April 29, 2022

RE: SYDNEY METRO WEST ENVIRONMENTAL IMPACT STATEMENT - SSI-22765520

M P Kohler  
Principal

Figure 4 North Strathfield metro station construction footprint

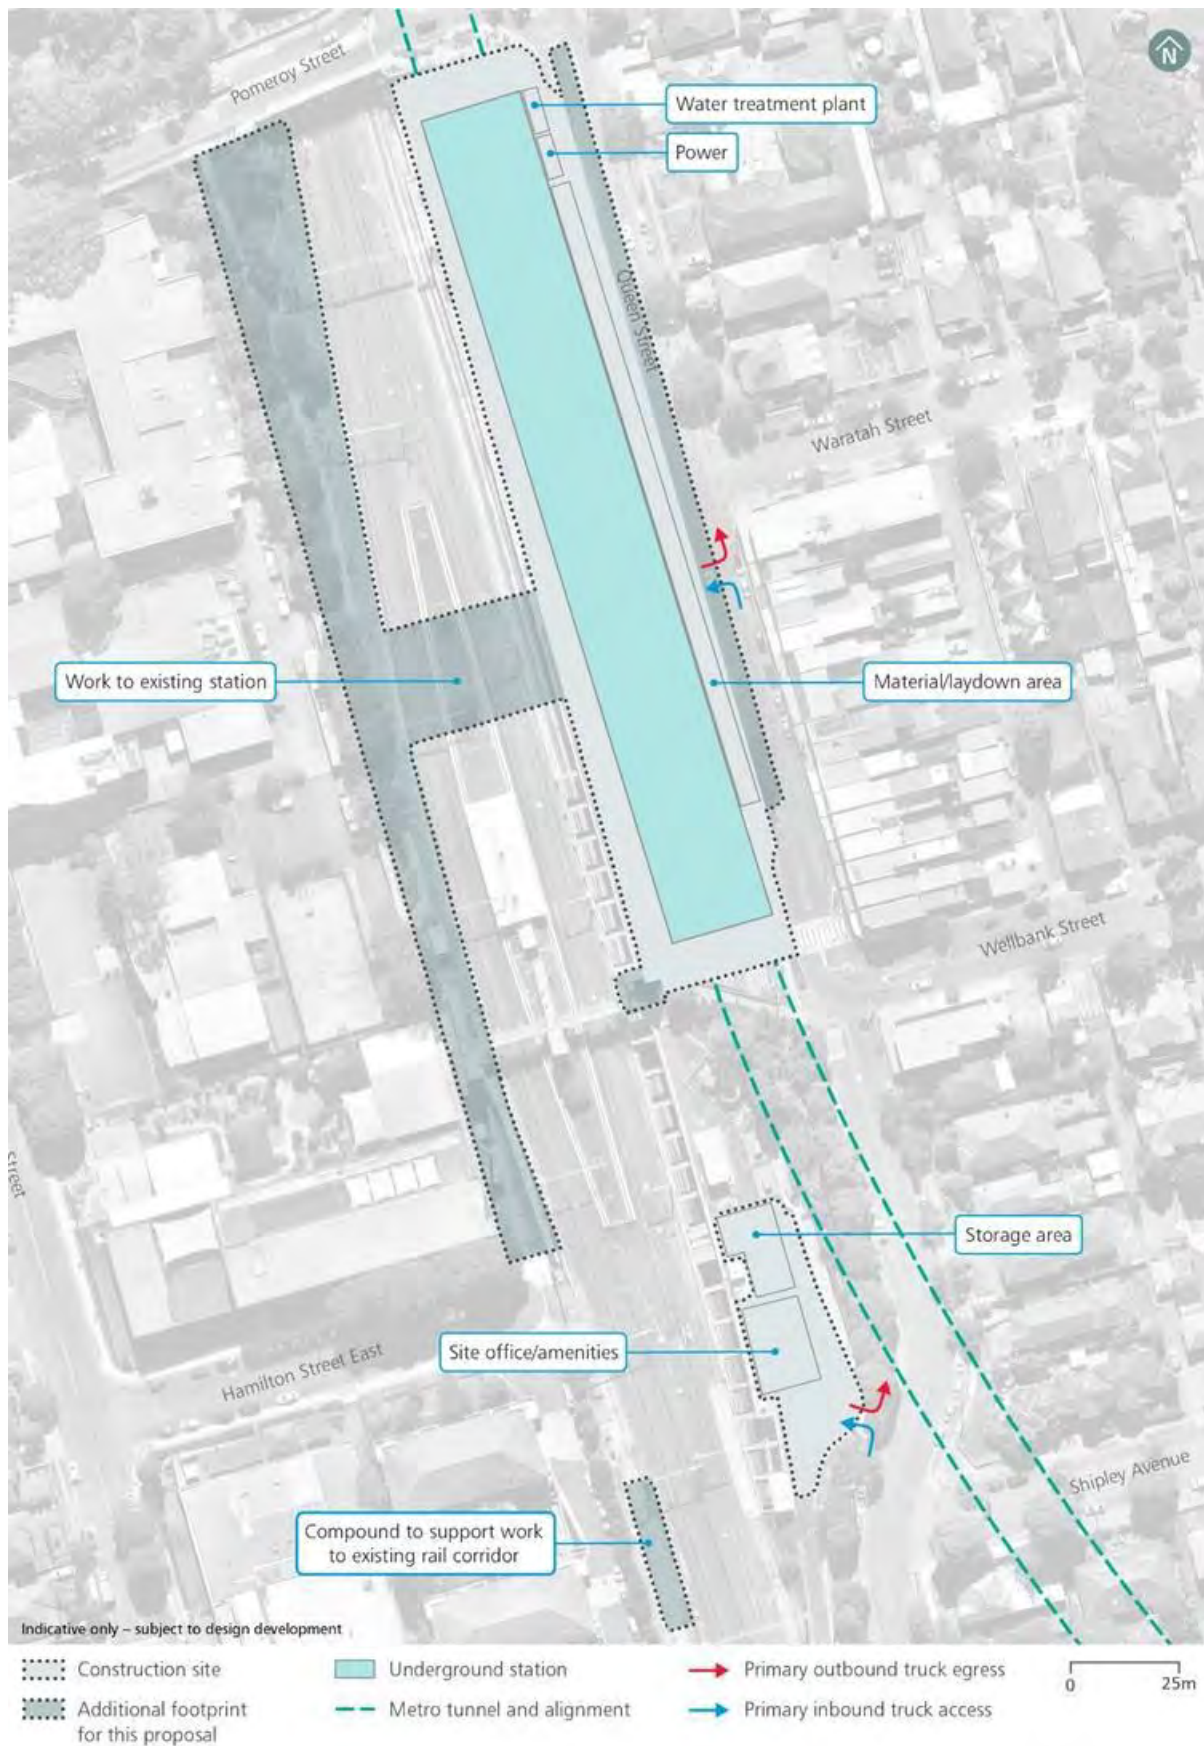
The EIS does not include any details or assessment of construction dust pollution impacts or provide any details of approaches to mitigate dust pollution during construction. Many of the students and some staff at The McDonald College are asthmatic or have dust allergies. By virtue of the College's close proximity to the proposed Metro Station construction, with the closest construction proposed to be directly adjacent to the boundary of our school's campus, impacts of dust pollution are of a critical concern to The McDonald College.

The EIS and accompanying acoustic report indicate that impacts to The McDonald College from construction noise will be acceptable on most occasions during the week, with intermediate 'moderate' acoustic impacts. The McDonald College is unable to understand the true impacts on our students and staff during these times given the lack of consultation. A not-for-profit educational provider should not be required to engage, at considerable cost, acoustic engineers to understand these impacts.

The EIS does not provide any commentary or assessment relating to impacts to students and staff accessing The McDonald College. The College is concerned that these impacts have not been adequately considered or assessed.

Looking at the proposed station concept, the plan to provide access for those on the western side of the heavy rail line by overhead bridges is poor. The solution harks back to the beginnings of Sydney's rail network 100 years ago and seems highly inappropriate for a modern metro system. The McDonald College has concerns regarding the capacities of the overhead bridges and lifts etc and the potential for students to be caught in crowd crush situations during peak times, which could occur in particular when large events are on at Sydney Olympic Park.

The EIS indicates that there will be removal of 24 on-street parking spaces on the western side of Queen Street between Wellbank and Pomeroy Streets without replacement of these parking spaces. This action will push these commuters into an already congested George Street seeking parking resulting in an increased safety hazard for the McDonald students and community. This impact will be further heightened by increased parking demand generated by construction workers who are working on the proposed Metro Station seeking parking in the nearby streets.

The EIS proposes a Kiss & Ride in front of the entry to Our Lady of the Assumption that neighbours The McDonald College. This location is not only a poor choice from the aspect that it is proposed to be located in a relatively narrow and short dead-end street, but at peak times when it is most likely to be used it will be in direct conflict with student drop offs for this school. In addition to the high likelihood that this will cause traffic impacts within the area that could impact traffic flow on George St at peak times, this proposal presents a clear risk to student safety. Increased car volumes and traffic chaos in close proximity to a large number of children will be an accident waiting to happen.
